Permit Number: 040898

This is to certify that Knight Thomas C. & North R. Builder
has permission to Build new 365 sq ft deck attached to single family residence
AT 88 Shepherd Ln City of Portland 351 A025001

Proposed Project Description:
Build new 365 sq ft deck attached to single family residence

PROPOSED DECK

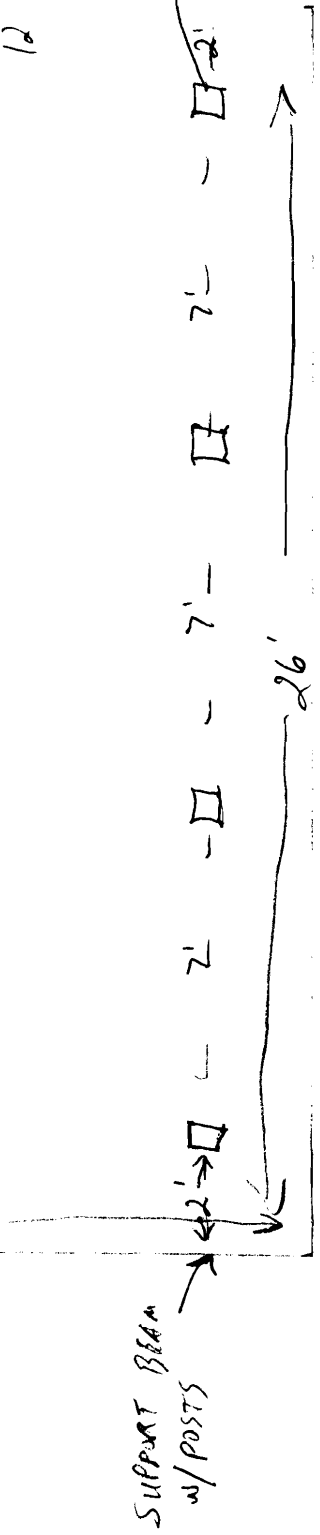
Comment Date	Comment				
<input type="text"/> 07/28/2004	<input type="text"/> Need size and depth of tubes, stair dimensions, ledger size and bolts, guardrail details, new openings in house to deck. <i>BUILDER IS OUT OF STATE & WILL CALL NEXT WEEK.</i>				
Name	<input type="text"/> tmm	Follow Up Date	<input type="text"/>	Completed	<input type="checkbox"/>

Comment Date	Comment	Name	Follow Up Date	Completed
<input type="text"/> 07/30/2004	<input type="text"/> ok to issue - contractor come in and made notes on plans.	<input type="text"/> fmm	<input type="text"/>	<input type="checkbox"/>
<input type="text"/> 07/28/2004	<input type="text"/> Need size and depth of tubes, stair dimensions, ledger size and bolts, guardrail details, new openings in house to deck, Spoke w/builder - they are out ofstate and will call the end of the week.	<input type="text"/> fmm	<input type="text"/>	<input type="checkbox"/>
